Objection to Residential Development with affordable housing 11-19 Middle Harbour road Road Lindfield (SSD-82900461)

EAST ELEVATION
1:200

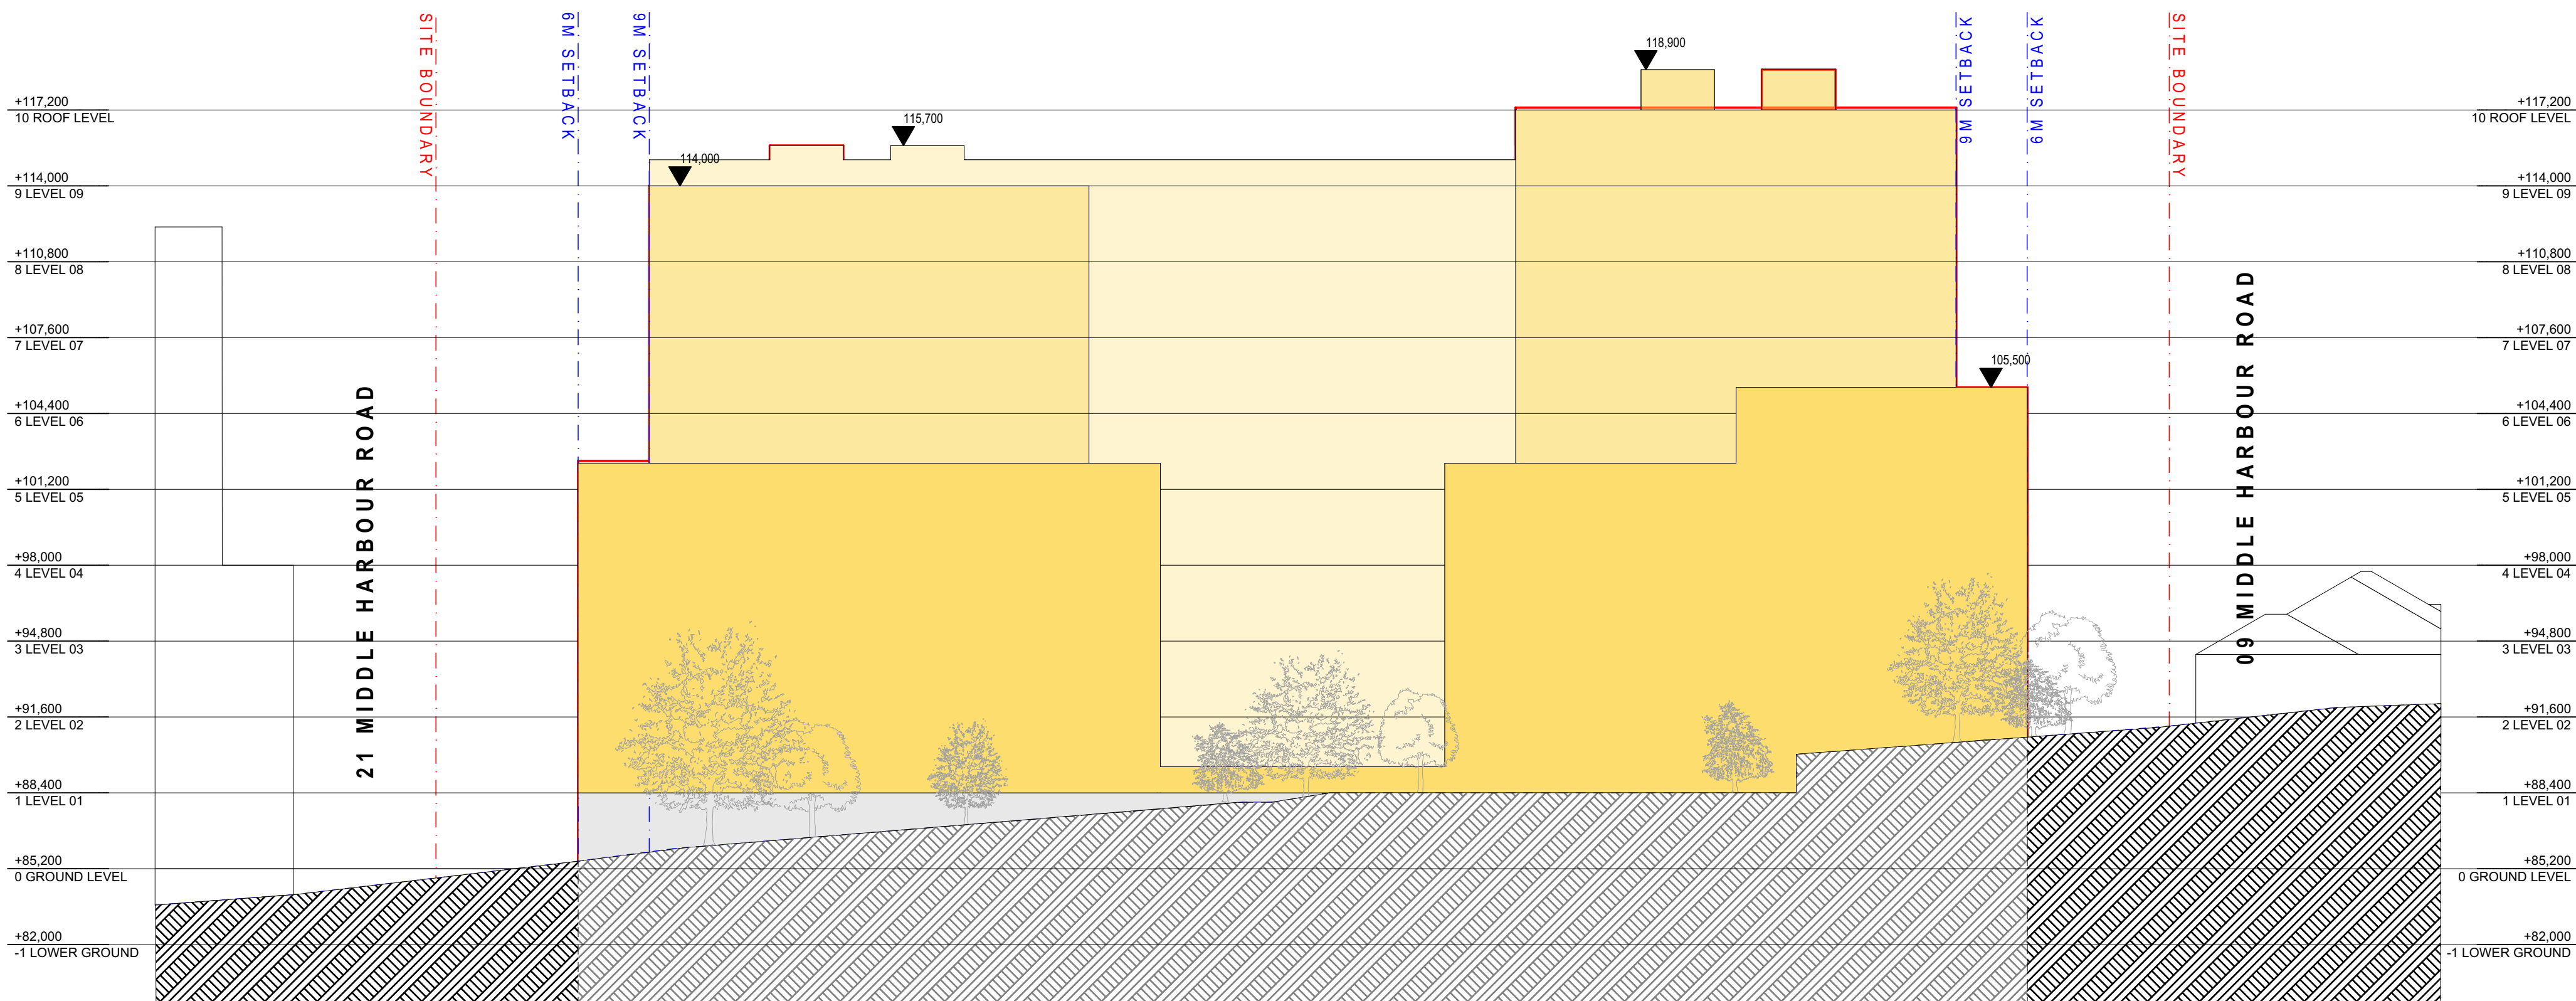
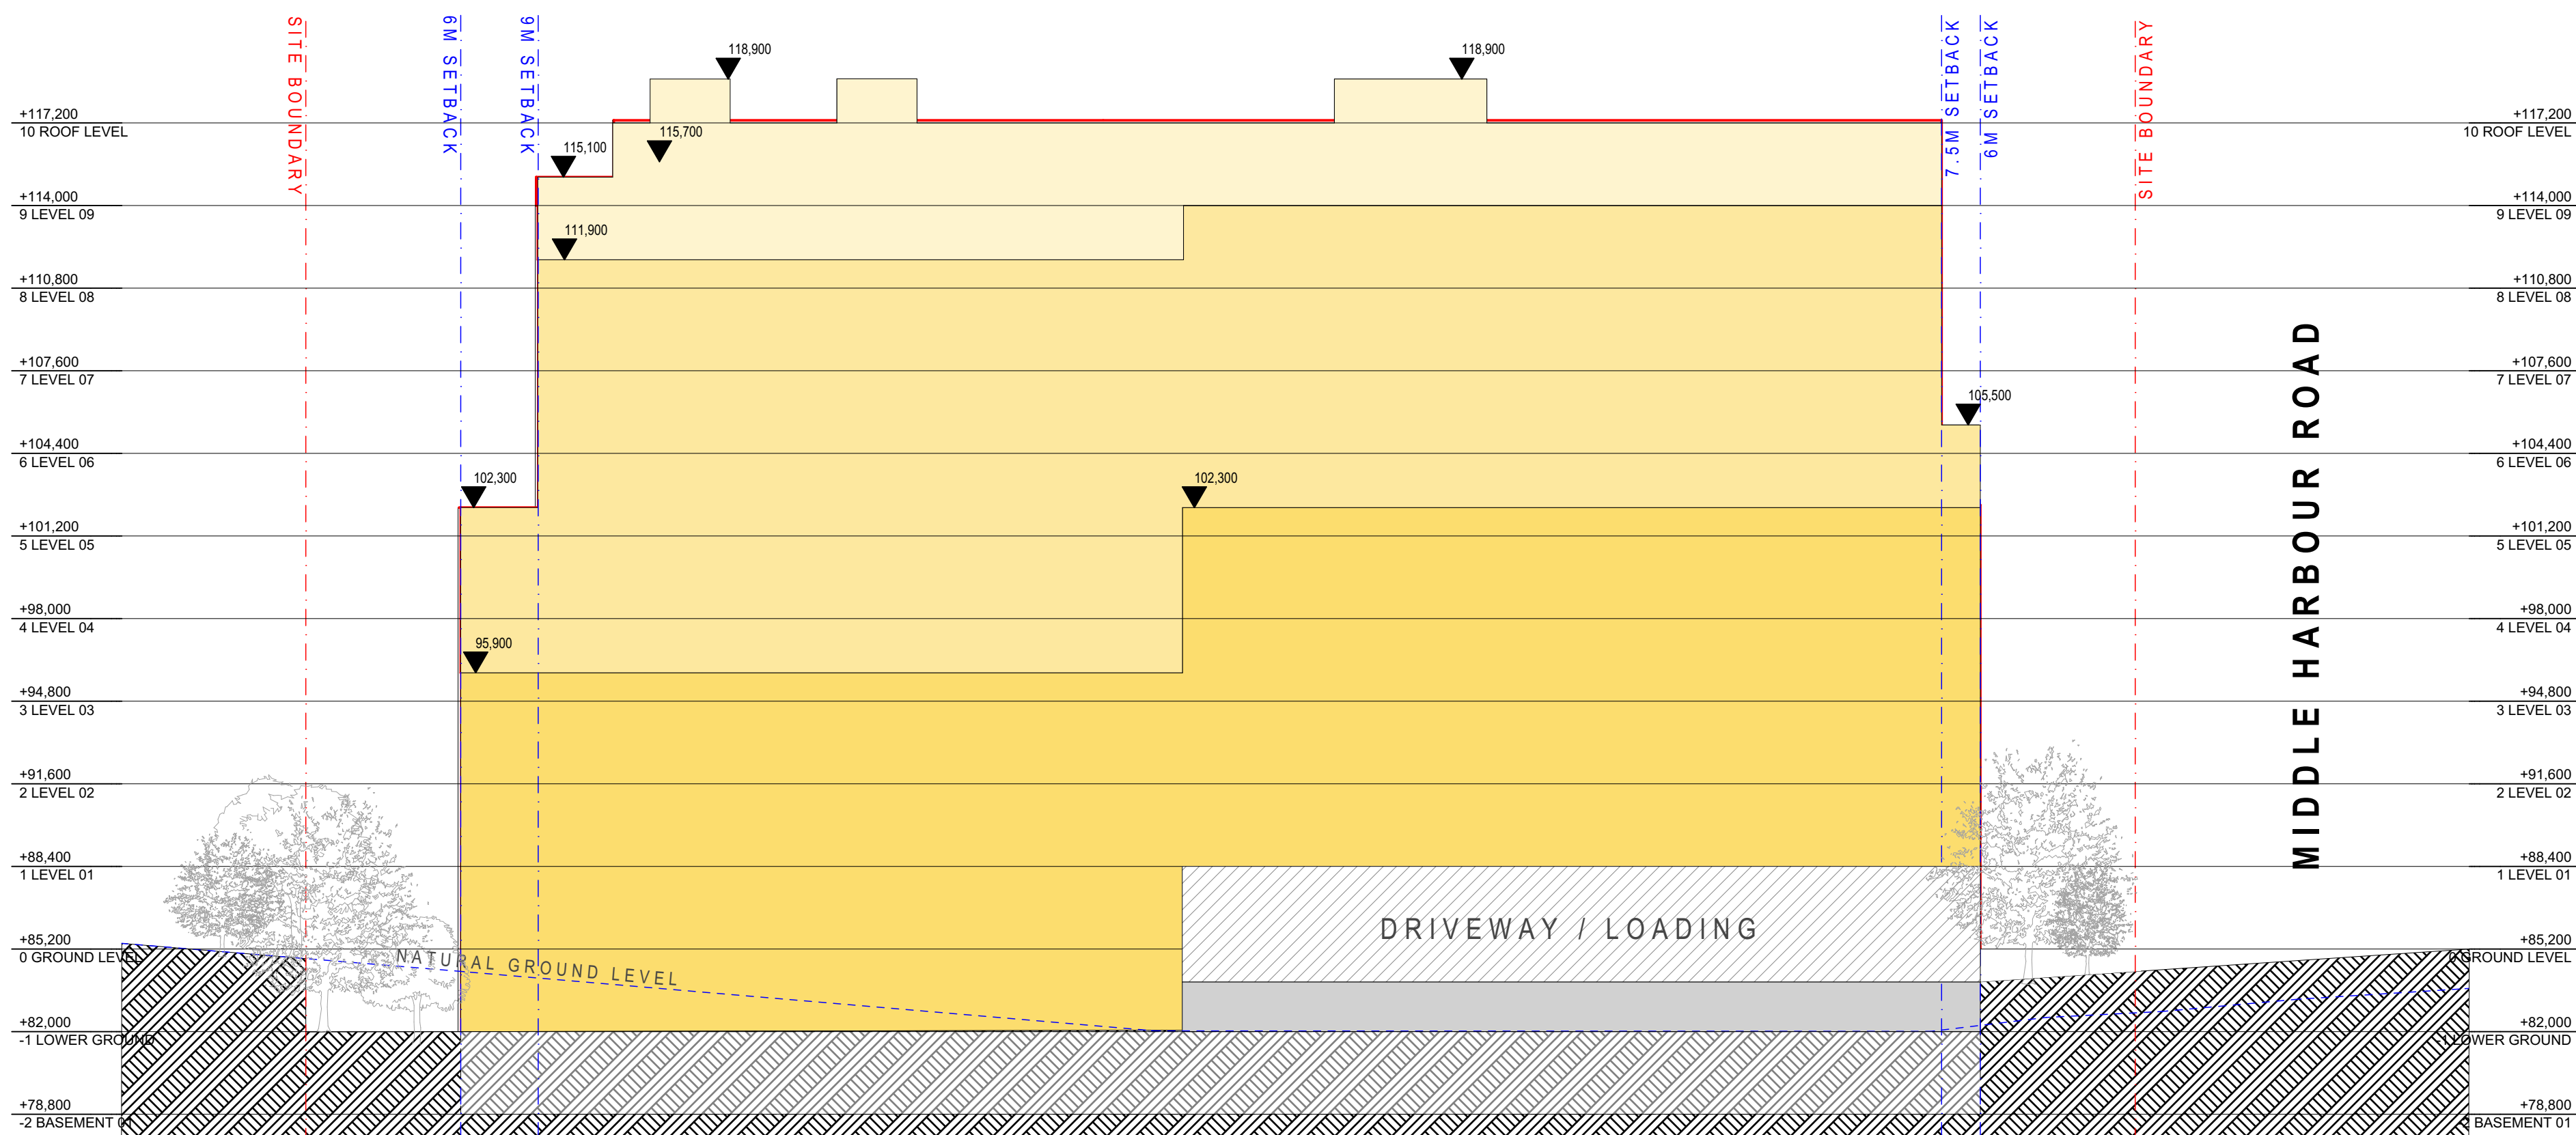
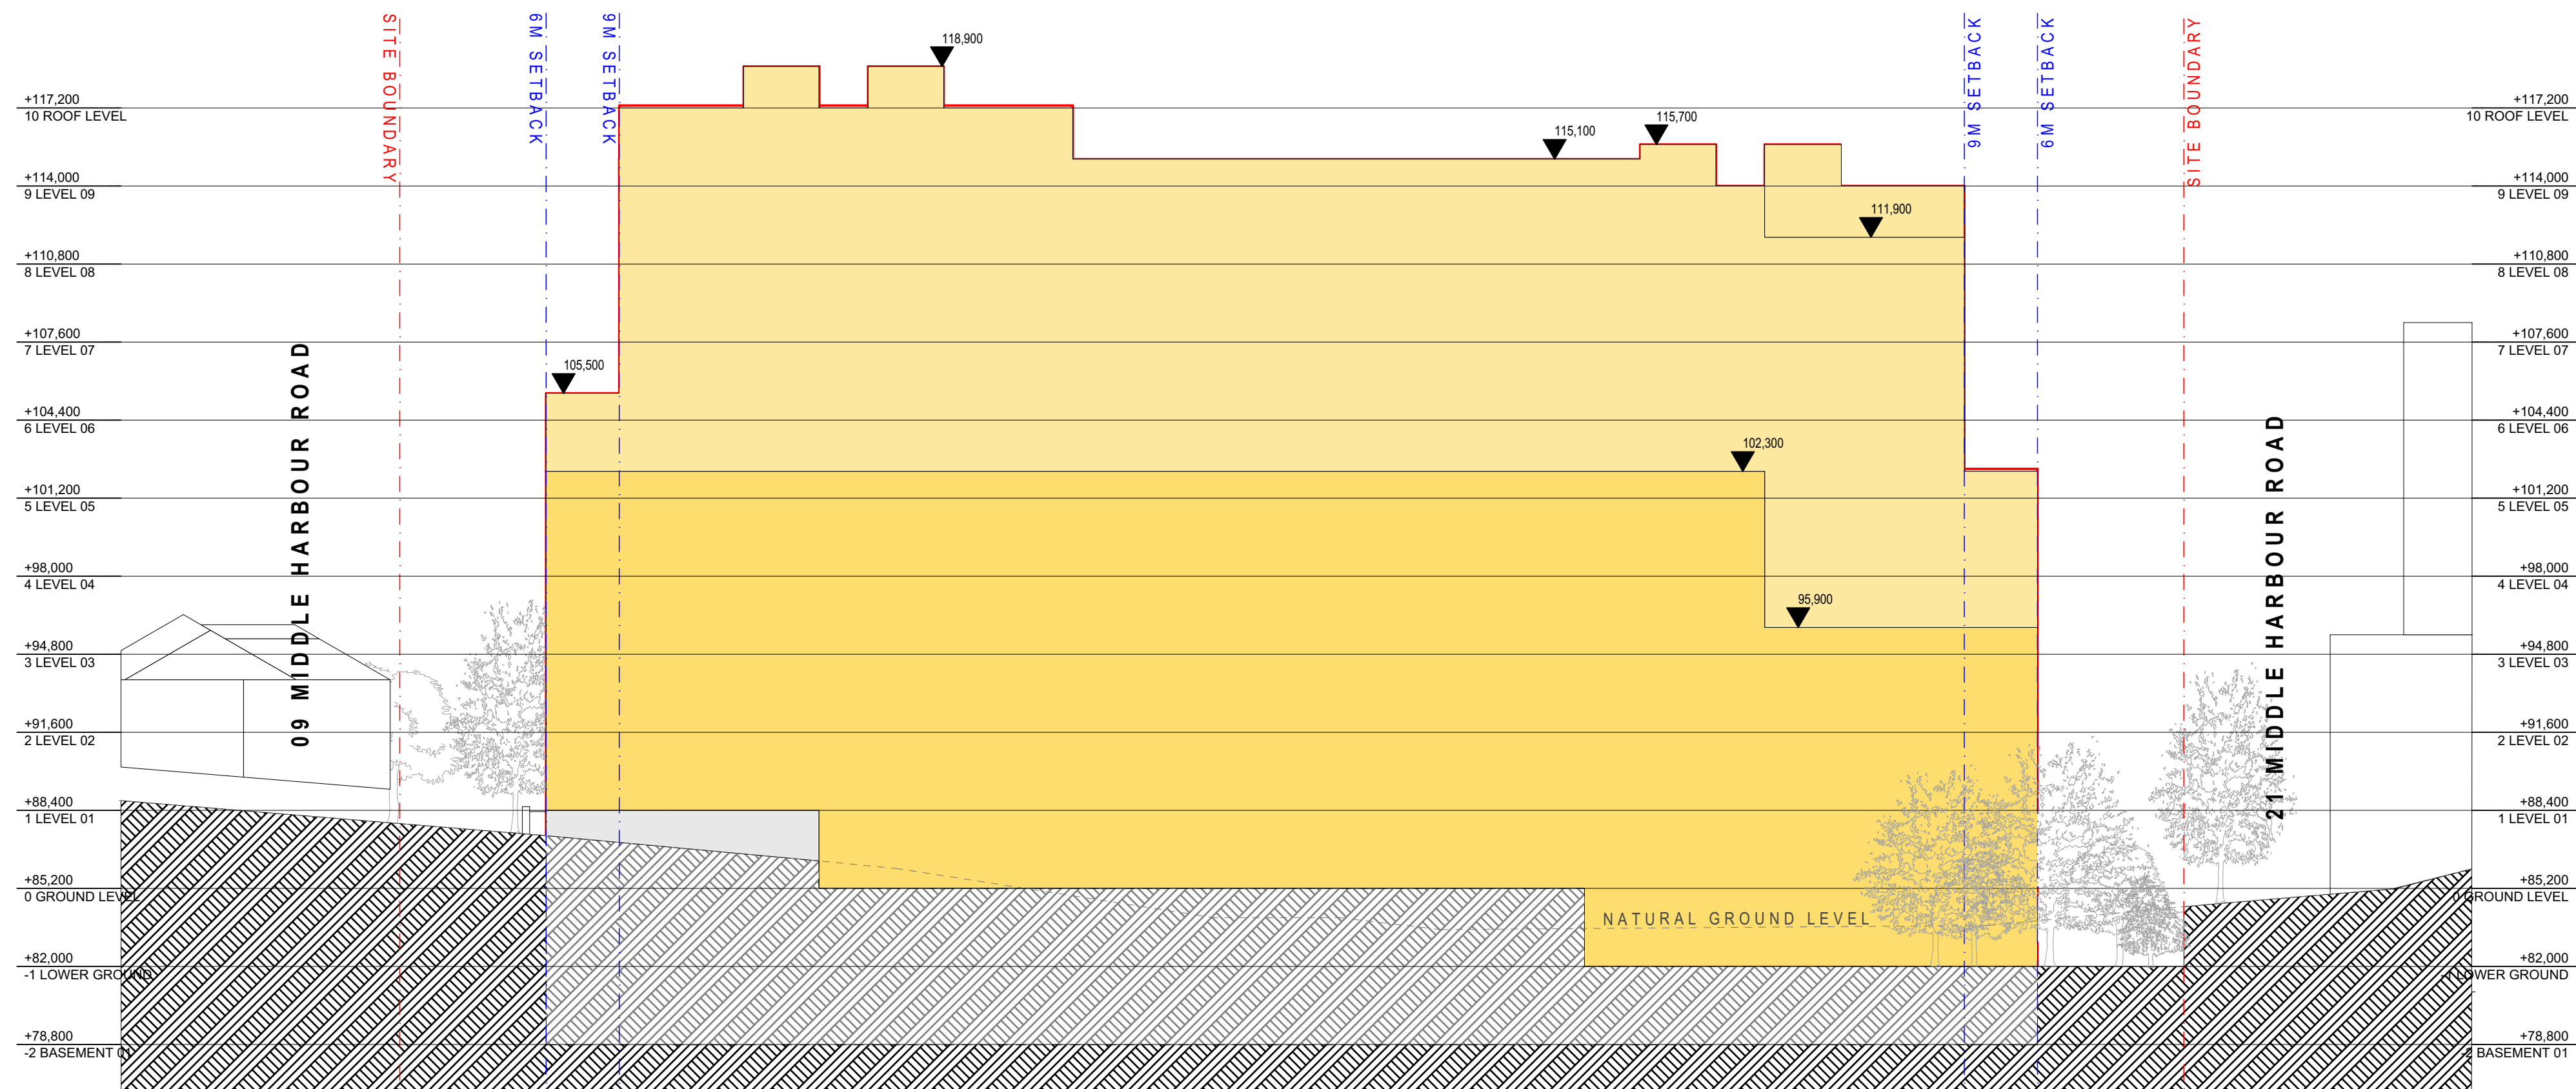
While the Project falls within the "Preferred Alternative" area, building heights in the area are limited to 18 meters to meet planning requirements for transitioning from a high-density to a low-density zone. However, the current design for the Project's buildings exceeds 30 meters, significantly contradicting the KRG's "Preferred Alternative" in both height and bulk.
